20 May 2013

**Re: Block 4S, Central Park – Student Accommodation and Commercial Development**

I refer to your email dated 17 May 2013 in which you requested Elton Consulting to review the relevant submissions / comments relating to Crime Prevention Through Environmental Design (CPTED) raised during public exhibition of the Planning Applications/Modifications for Blocks 1 and 4 at Central Park, Chippendale.

GROUND & LEVEL 00 PLAN

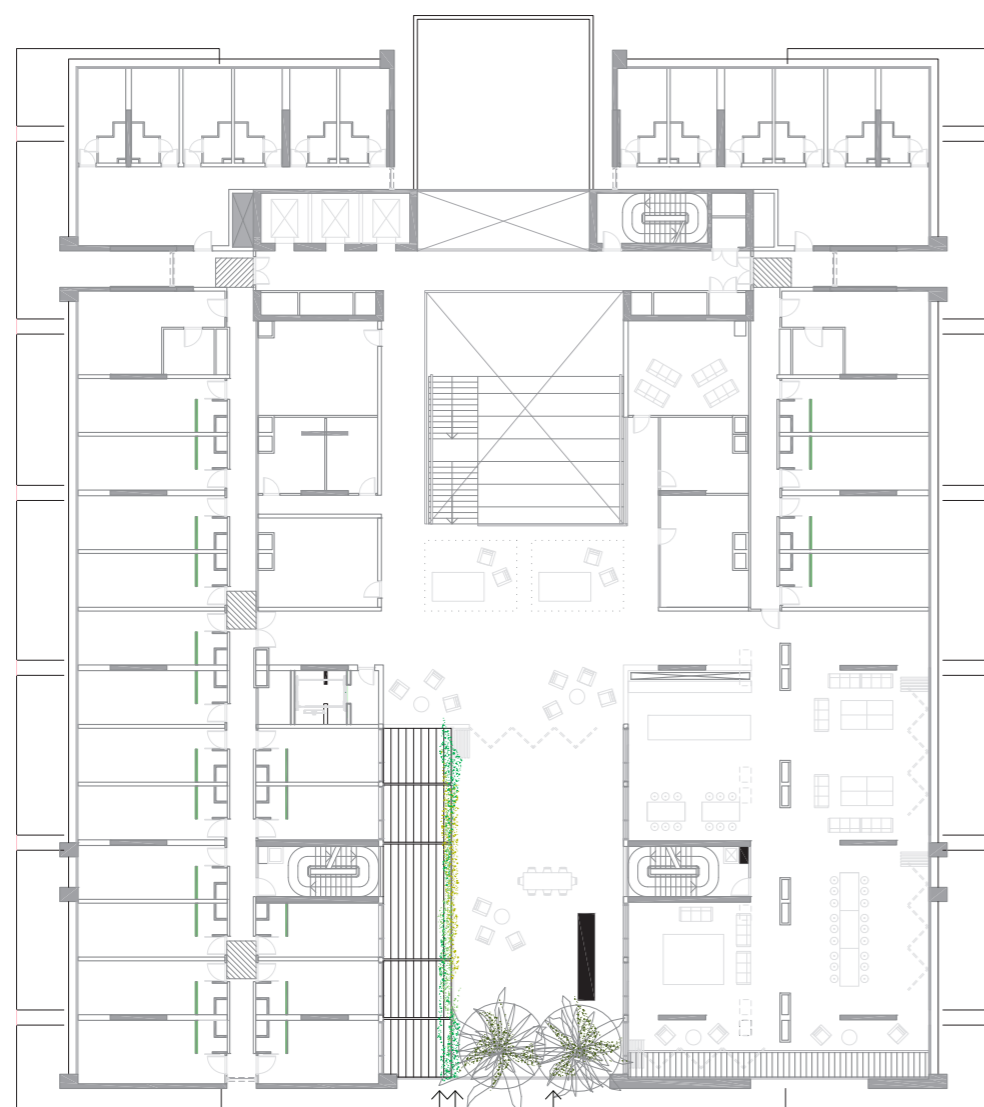
*Comment:* Modifications to the southern elevation of the student accommodation building (frontage facing Irving Street) include the removal of a temporary loading dock, which is replaced with active retail use.

As shown in the *Ground Floor and Level 00 Plan* prepared by Jeppe Aagaard Andersen & Turf Design Studio, the retail tenancy in the south-eastern corner of Block 4S wraps around to Irving Street to continue the active retail edge. The addition of retail uses along the Irving Street frontage creates improved opportunities activity at this street frontage. Irving Street terminates at Central Park Avenue opposite the main public park, and is therefore envisaged to be a highly used pedestrian thoroughfare with pedestrians accessing the public park from Abercrombie Street and areas further west.

Activating the building edges at the ground level with retail uses, supported by landscaping and awning features to make the space attractive and amenable, is seen to contribute to creating activity and a perception of safety. The use of glazing and shop fronts at the ground level on the southern elevation reinforces the opportunity for surveillance of the public domain along Irving Street and beyond. Glazing at the ground level also assists to deter vandalism, with fewer large expanses of blank brick walls that would attract opportunities for graffiti.

## Ground Floor

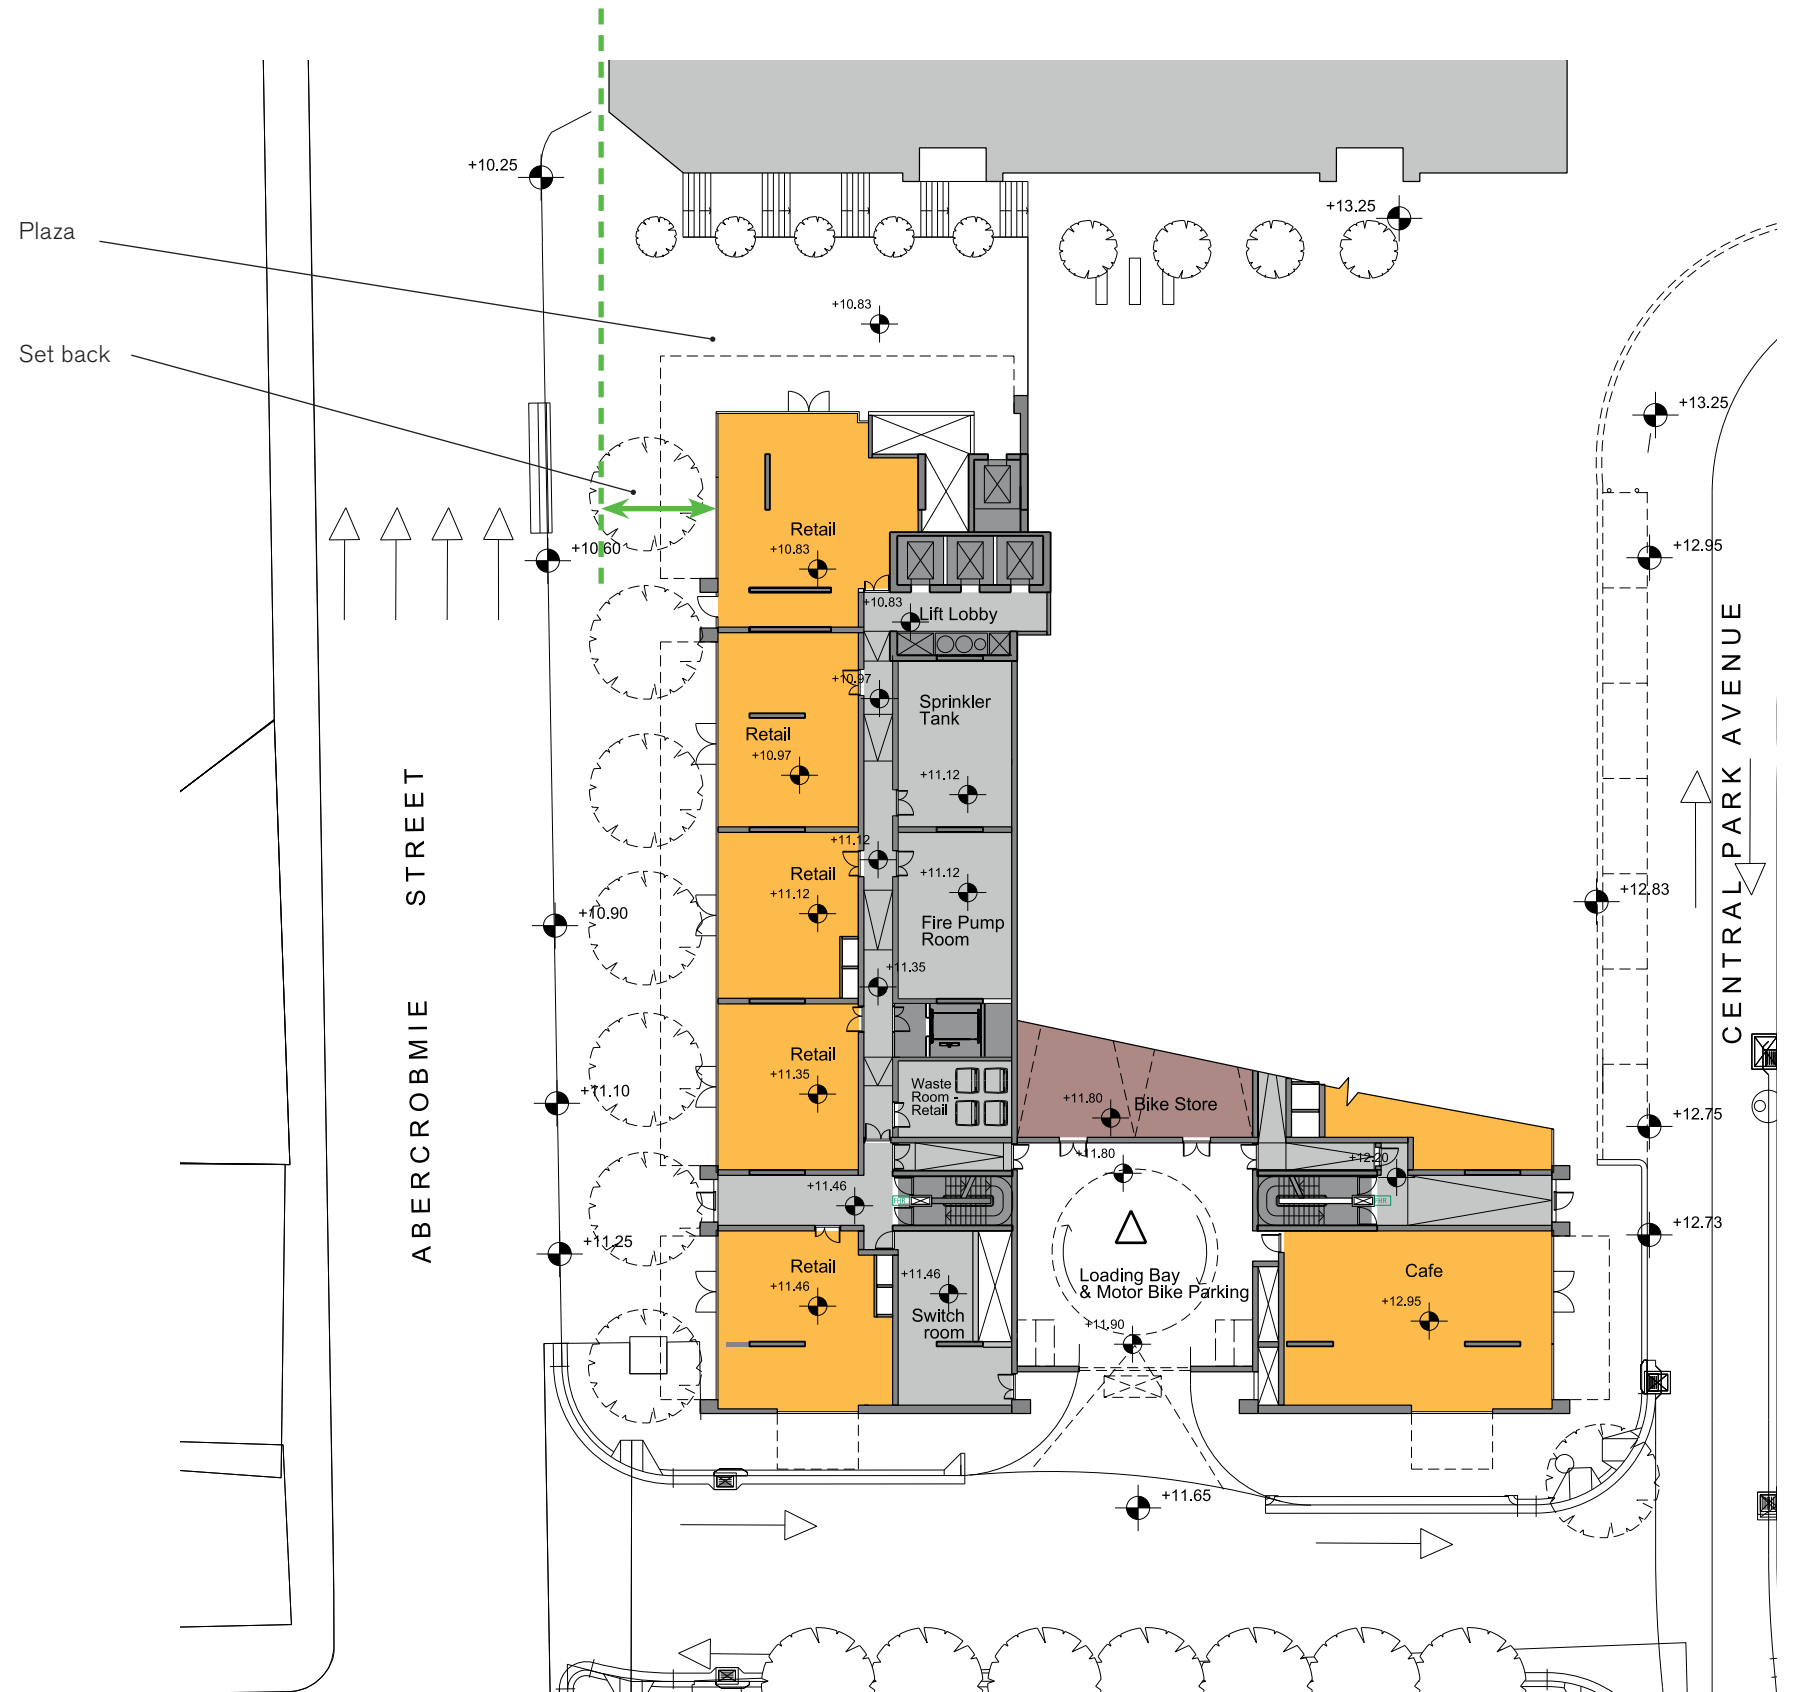
#### **1. Public domain area between Block 4N and 4S**

*Comment:* A separation between Block 4S and 4N creates a public link / pedestrian walkway between Abercrombie Street and Central Park Avenue. The public "through link" has been designed as a high quality pedestrian area with good levels of public amenity so as to contribute to crime prevention and safety measures.

- The "through link" will generate pedestrian activity as it is the main entrance to the proposed Block 4S student accommodation facility. It also acts as a pedestrian walkway across the Central Park from east to west.

- The "through link" incorporates lighting and landscape elements that will make the area amenable, attractive and encourage people to sit and enjoy the surroundings, such as feature lighting, tree plantings, seating, a water feature and bike racks.

- Activity generating uses are located at the ground floor level on both Block 4S and Block 4N frontages of the "through link", including retail, cafe and the student accommodation lobby / entry, which will each encourage people to visit, walk-through but importantly stay in the area and provide passive surveillance opportunities.

- Awnings / overhead cover is provided along part of all four frontages of the student accommodation building, which contributes to making this an all-weather, pedestrian-friendly environment with the potential for outdoor seating associated with cafe and restaurant uses. These awnings also provide an element of privacy to student dwellings above.
